Ribble Valley Borough Council
Council Offices
Church Walk,
Clitheroe
Lancashire
BB7 2RA

Phone: 0300 123 6780
Email: developeras@lancashire.gov.uk
Your ref: 3/2025/0713
Our ref: 3/2025/0713/HDC/KW
Date: 09 October 2025

Location: 15 Caton Close Longridge PR3 3RH
Proposal: Proposed change of use from C3 Dwellinghouse to C2 Children's Residential Care Home (solo occupancy)
Grid Ref: 360806 437545

15 Caton Close, Longridge, PRESTON, PR3 3RH, UNITED KINGDOM

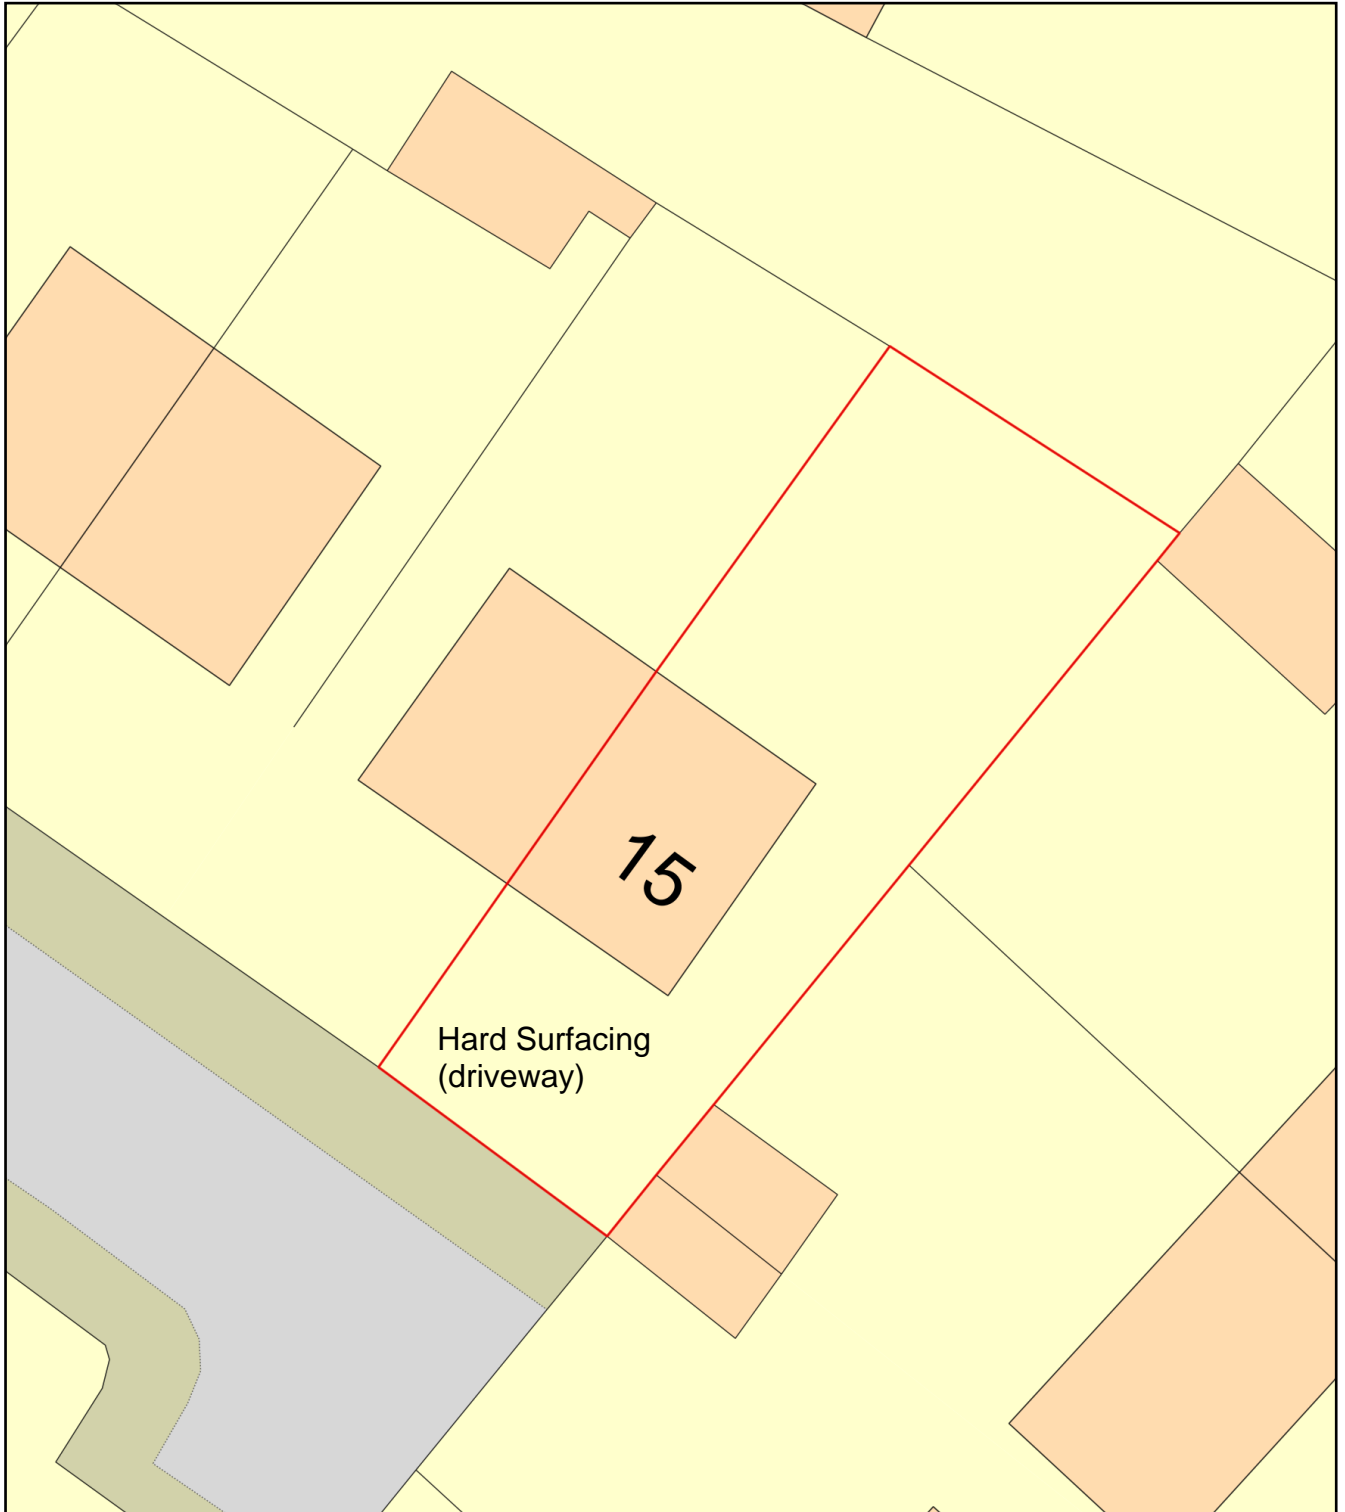
The site is accessed from Caton Close, during a site visit, it was noted that whilst the existing driveway has been extended internally, the vehicle crossing situated within the highway has not been extended across the entire driveway opening. Therefore, prevent damage to the footway and to protect the services beneath the footway, the existing vehicle crossing should be extended across the entire driveway opening. This will also support acceptable access to off-street parking provisions. The extended vehicle crossing within the adopted highway will need to be constructed under a section 171 agreement of the Highways Act 1980.

The LHA have reviewed the site plan and are aware that there are 2 off-street parking spaces within the existing driveway. When considering how the site will operate as described within the Management Plan, there will be 2 members of staff present as such off street parking can meet the regular staffing needs. Whilst normally the LHA would require further off street parking to be provided to support external visitors, given the size of the site, this is unlikely to be feasible.

The road fronting the dwelling could cater for an additional on street parking space, which during the visit would block the use of the driveway. This could be used by any short-term external visitors should it be required. As such, the effect of the development on the operation of the local highway network would be negligible.

1. The development hereby permitted shall not be occupied or brought into use until the car parking shown on the approved plan has been provided in full and is available for use. The car parking and turning areas shall thereafter be kept available for the parking and manoeuvring of vehicles at all times.

2. Within three months of this permission drop kerbs must be installed at the carriageway edge and a vehicle cross-over constructed across the footway fronting the site access.
